DRB Application No.: 04DRB-00552 (FP)

Project # 1002663

Project Name: El Porvenir

RE: El Porvenir/final plat

**PLAT OF
LOTS 1 thru 13
EL PORVENIR SUBDIVISION
SITUATE WITHIN SECTION 17,
T. 10 N., R. 3 E., N.M.P.M.
CITY OF ALBUQUERQUE
BERNALILLO COUNTY, NEW MEXICO
OCTOBER 2003
SHEET 2 OF 2**

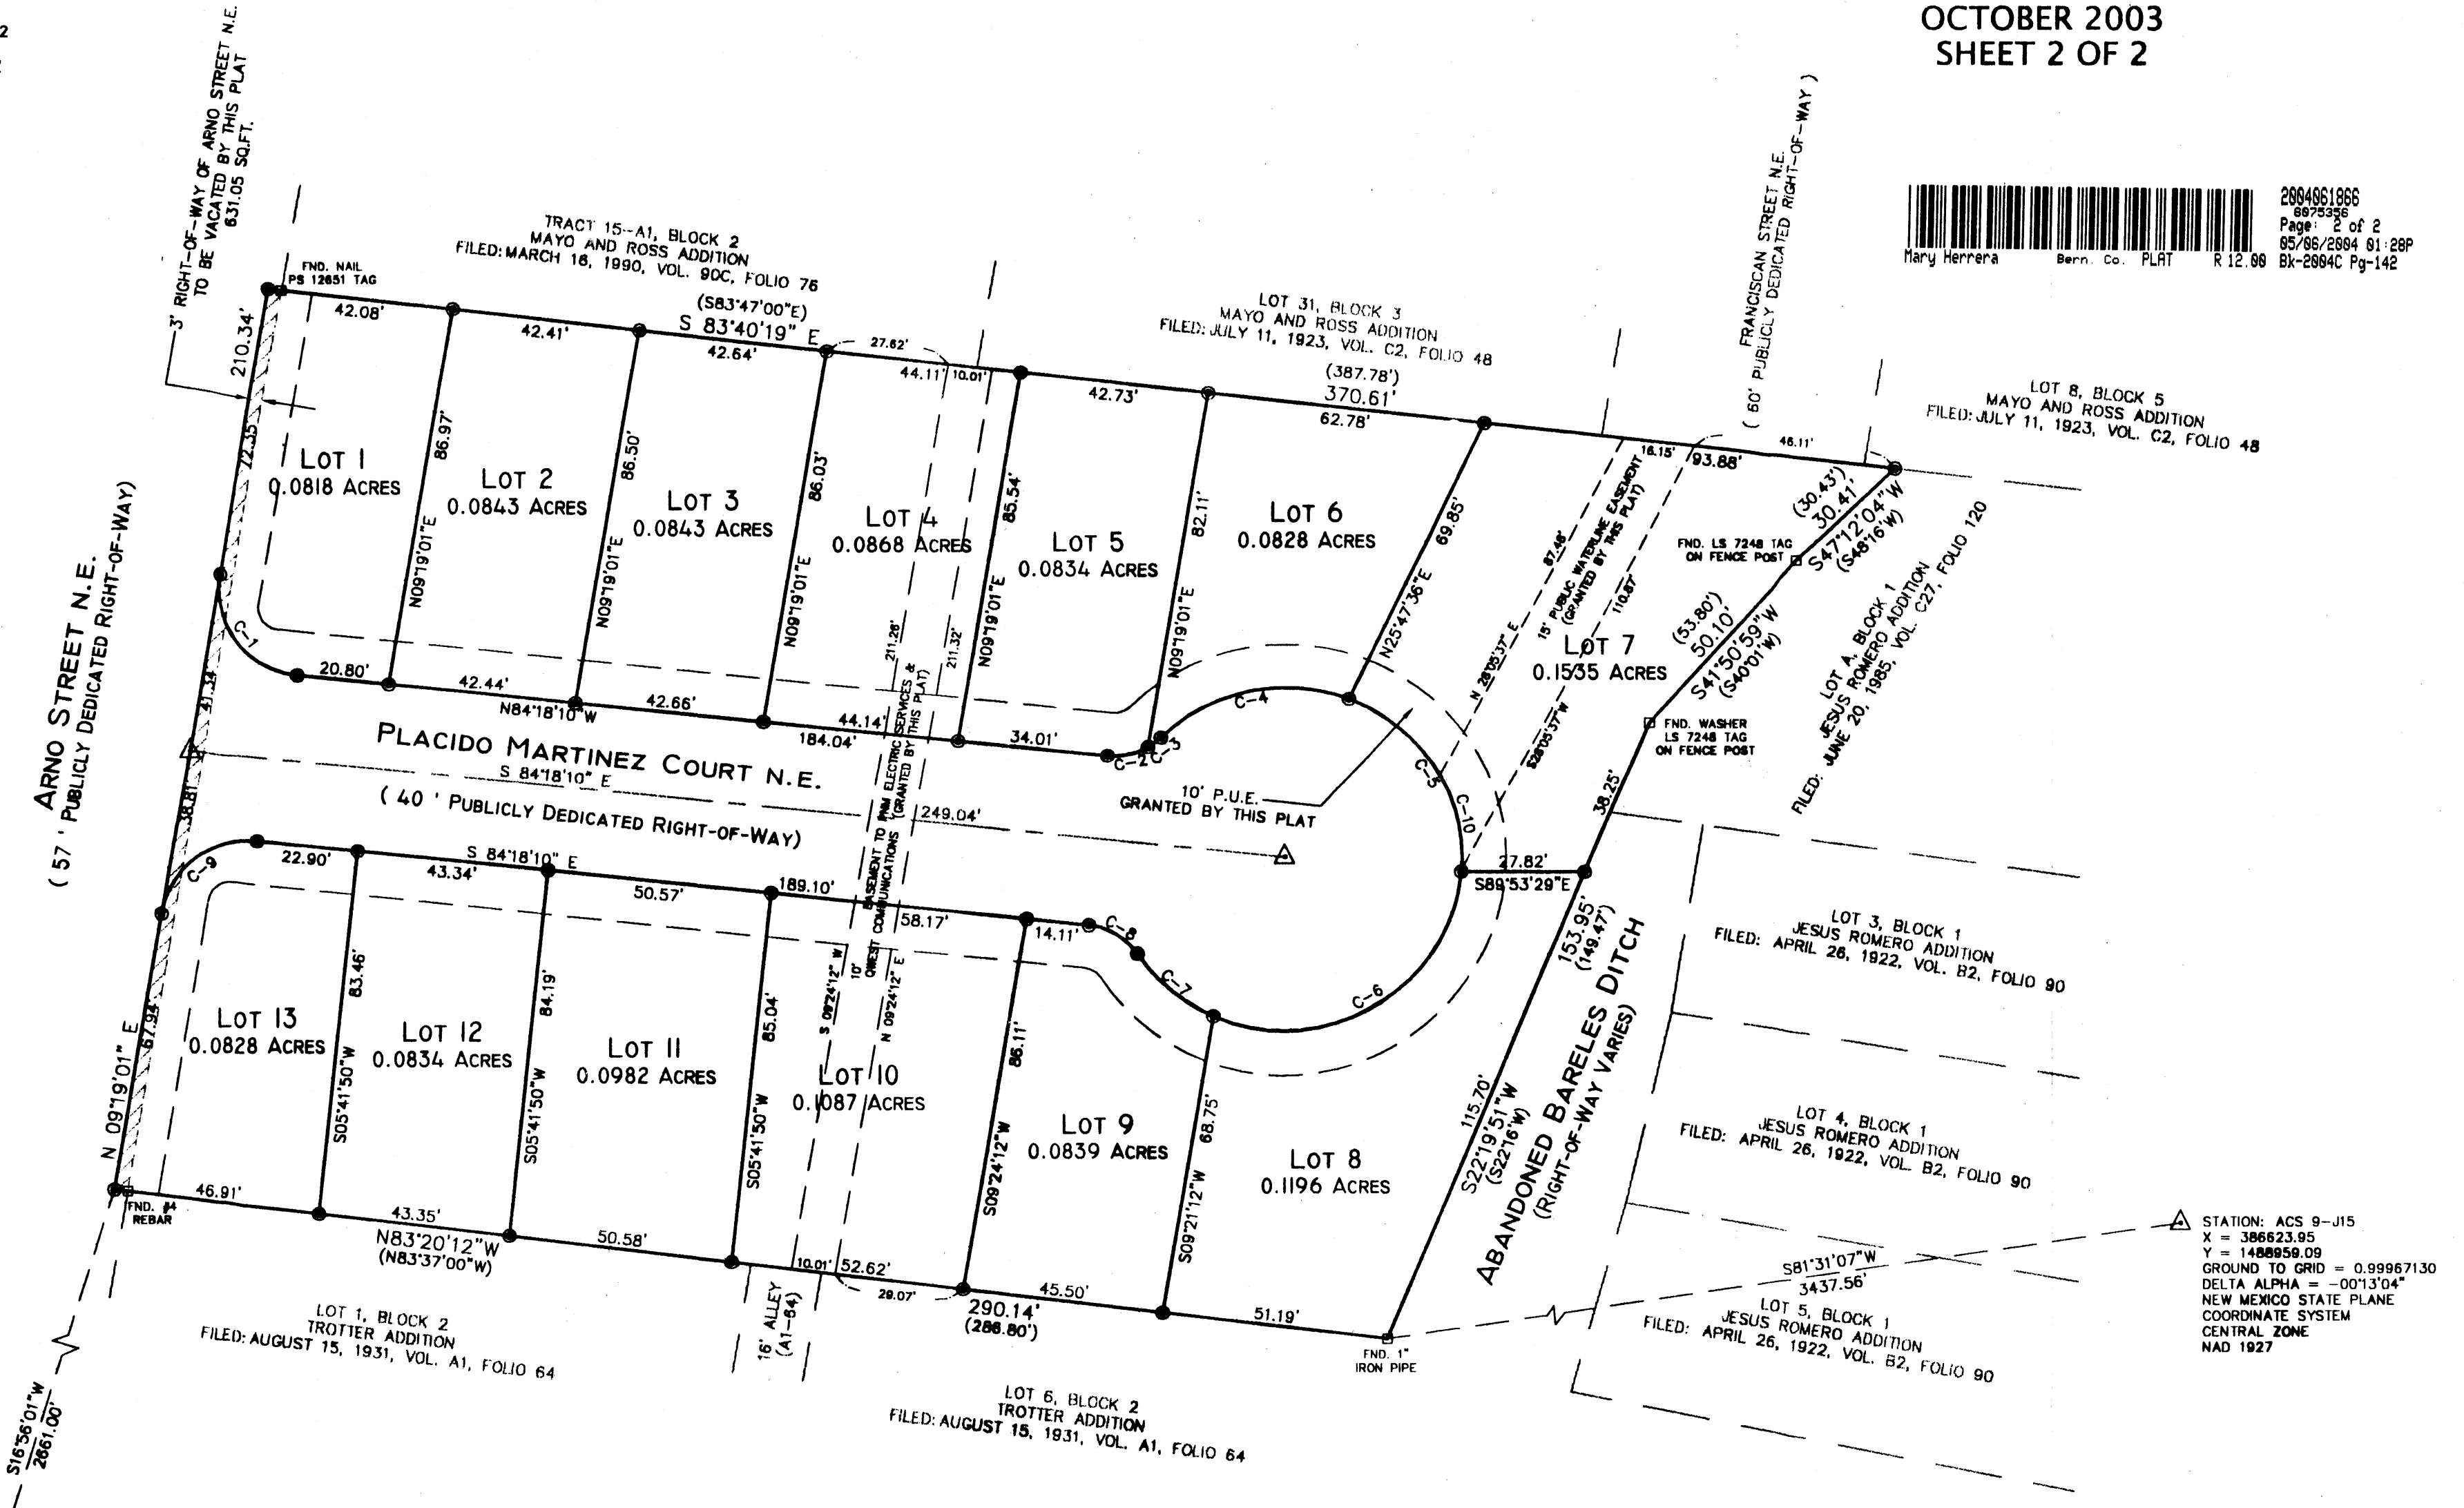
A condition of final plat was to: "Reflect the radius as 20 feet instead of 15 feet." Was this change made?

Were there any other changes to the final plat?

- 1) Reflect the radius as 20-feet instead of 15-feet.
